DOC18/705514
MP06_0308 MOD 3

Sunnyside Coal Mine MOD 3 invitation to comment

Thank you for your invitation for the Office of Environment and Heritage (OEH) to comment on the environmental assessment (EA) for the proposed modification (MOD 3) to the approved final landform for the Whitehaven Sunnyside Coal Mine.

Figure 4: Conceptual final land-use showing Koala habitat protection and enhancement areas

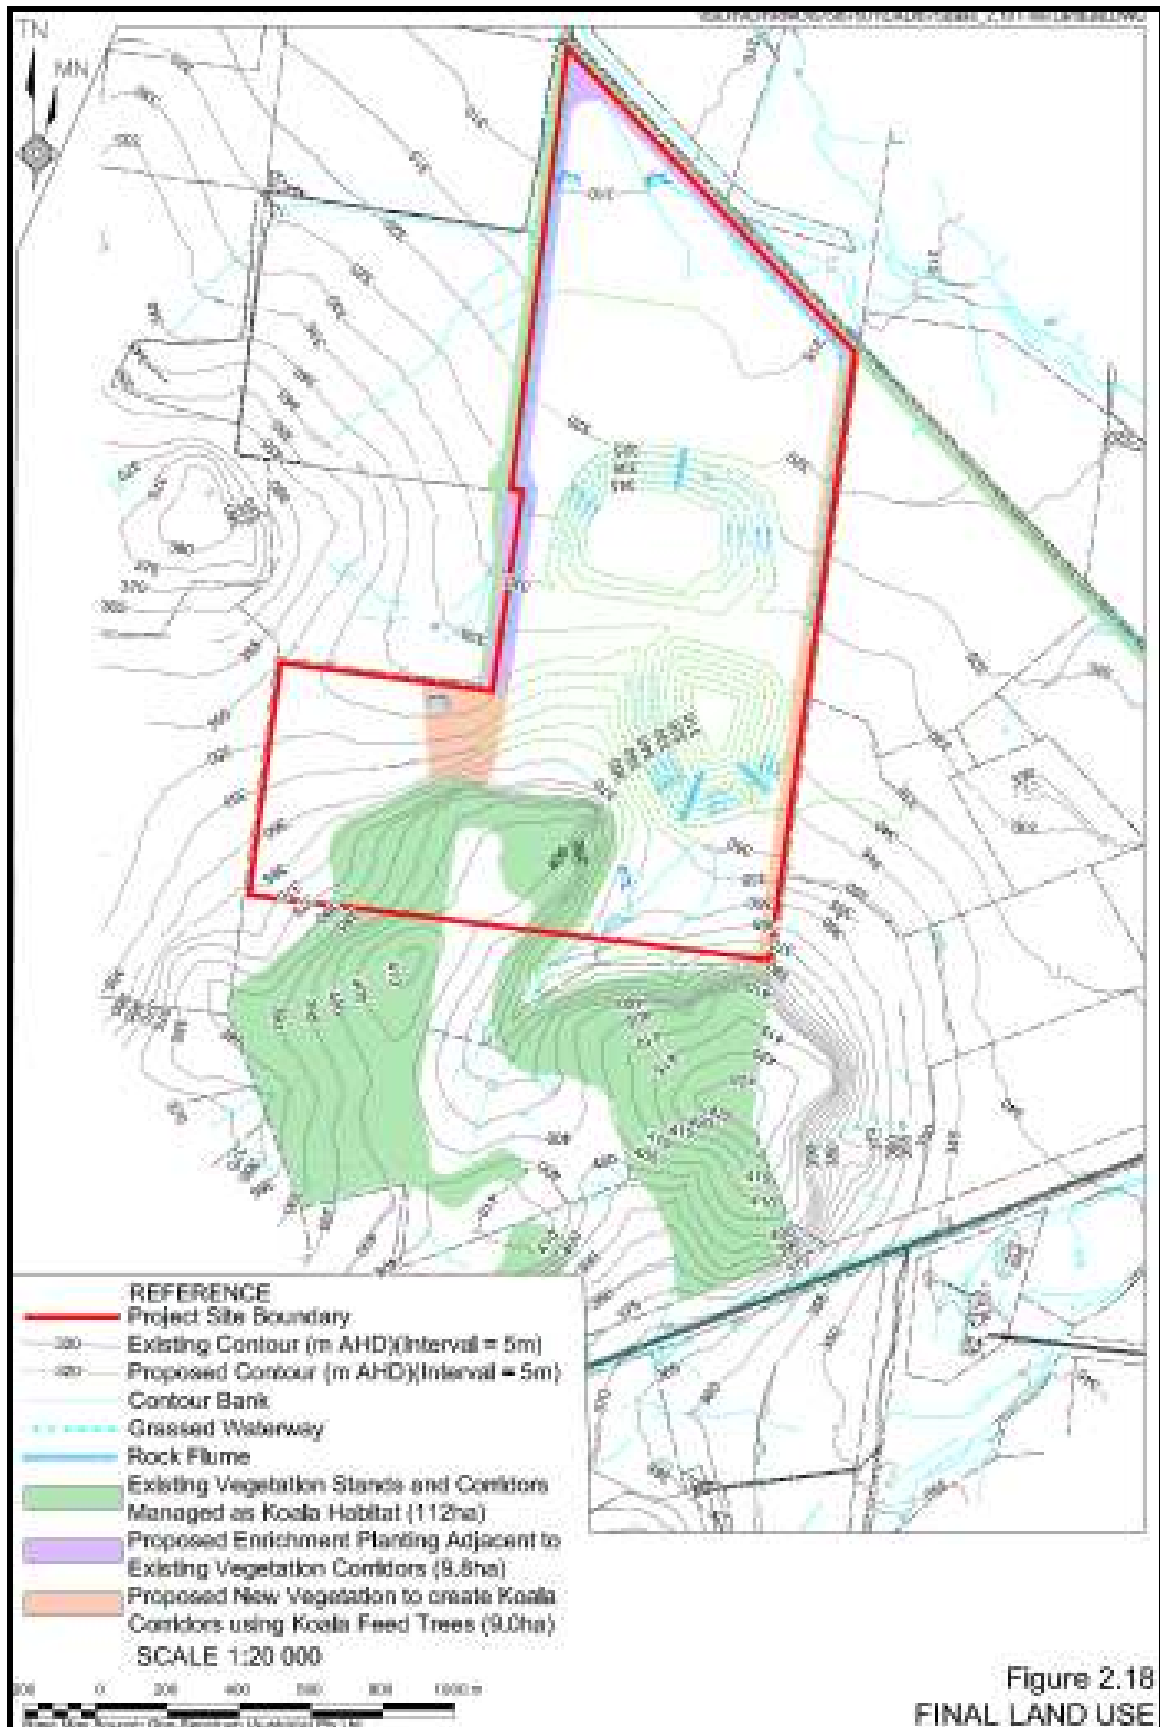
OEH understands that the proposed modification will not involve additional surface disturbance beyond the current approved development footprint. However, a portion of the areas designated as *'proposed new vegetation to create Koala corridors using Koala feed trees'* and *'proposed enrichment planting adjacent to existing vegetation corridors'* in the 2008 project approval (depicted in Figure 9 of the MOD 3 EA) would be affected by the proposed final landform changes.

The MOD 3 EA does not state the area of the previously approved Koala habitat plantings that will be affected, nor does the EA present a proposal for replacing these. The proponent states that this impact will be addressed in a revision to the Koala Management Plan which formed part of the EA for the original project.

The modification should ensure that the final area of Koala habitat, habitat enhancements and width of movement corridors established and protected are not less than those set out in the original project EA as required under the existing project approval.
